CITY OF ALBUQUERQUE

**Re: Hoilday Bowl
&515 Lomas
Request for Certificate of Occupancy
Transportation Development Final Inspection
Engineer's/Architect's Stamp dated 04-16-2018 (J19D082A)
Certification dated 1-18-2019**

DO NOT ENTER - ONE WAY SIGN DETAIL
NTS

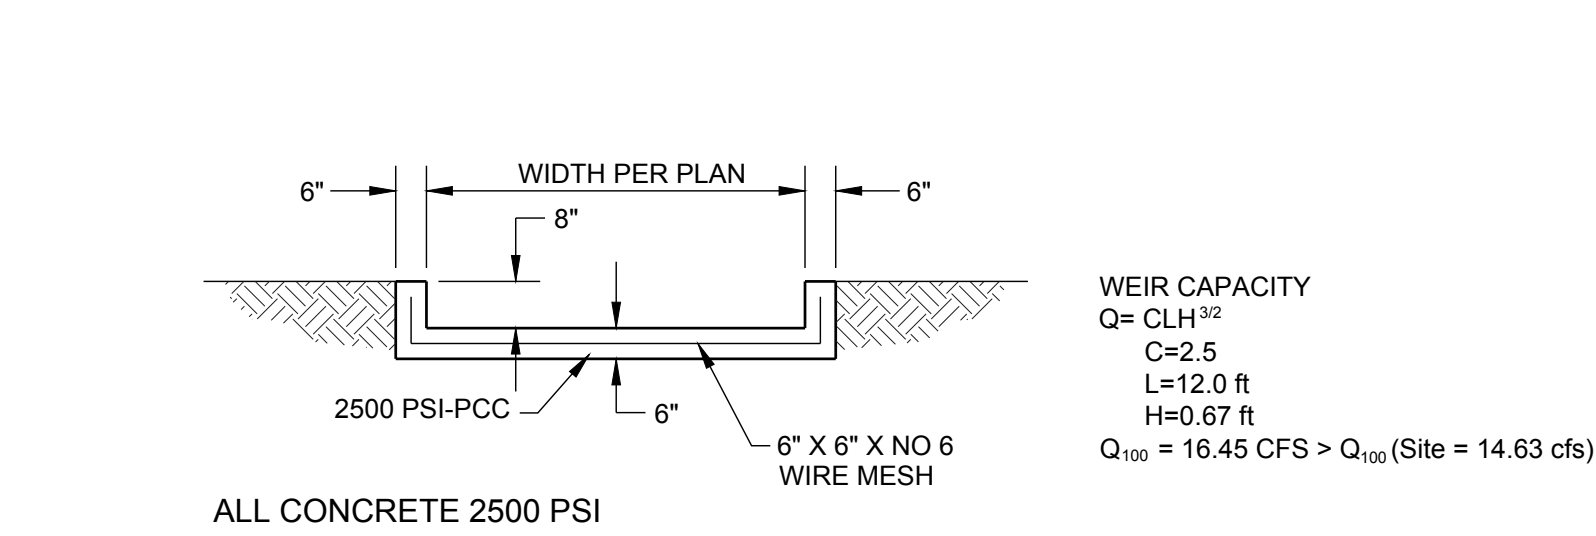
- The way these 2 signs are stacked on top of each other is confusing. We suggest that the "DO NOT ENTER" sign to be removed. Add a "DO NOT ENTER" Marking on the pavement.
